**Consultation Response from: KC Environmental Health (Pollution & Noise Control)**
**2023/92061 119, Huddersfield Road, Mirfield, WF14 9DA**
**Discharge of conditions 6 (right-turn lane), 8 (Construction Management Plan), 10 (electric vehicle charging), 11 (Phase II report), 16 (Air Quality Impact Assessment), 18 (temporary drainage), 20 (surface water drainage), 22 (hardstanding drainage) and 27 (external lighting) of previous outline permission 2019/92221 for demolition of existing buildings and erection of Class E retail unit, access, car parking, servicing, landscaping and associated works (all matters reserved other than access)**
**Date Responded:  
16<sup>th</sup> October 2023**
**Responding Officer:  
RM, SR, NH**
**Responding Ref:  
WK/202328147**

The following comments relate to conditions 8(Construction Management Plan) ,10 (Electric Vehicle Charging), 11 (Phase Report), 16 (Air Quality Impact Assessment) only which are within the remit of Environmental Health.

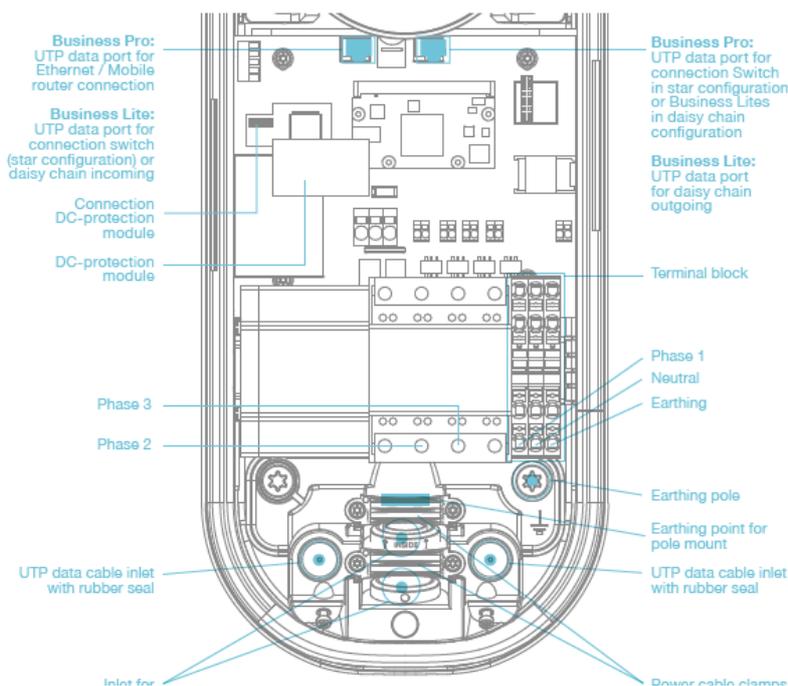
The Electrical Engineering Services External Lighting drawing by Wilson Gray Consulting dated Sep 2023 (ref: 79-E0000 Revision P03) shows four electric vehicle charging symbols in four parking spaces but it does not provide any further information. The new charging point overview sheet provides details of two EVCPs (Business Pro 2.1 and Business Lite 2.1). These provide up to 22kW of power via a Type 2 EV socket. The supporting standard store specification file document confirms the installation as shown in the plan.

On the basis that the proposals are to simultaneously provide fast electric charging for 4 vehicles at any given time, we accept the information. However, the planning officer must confirm the arrangement. We recommend the condition remain until the development is complete.
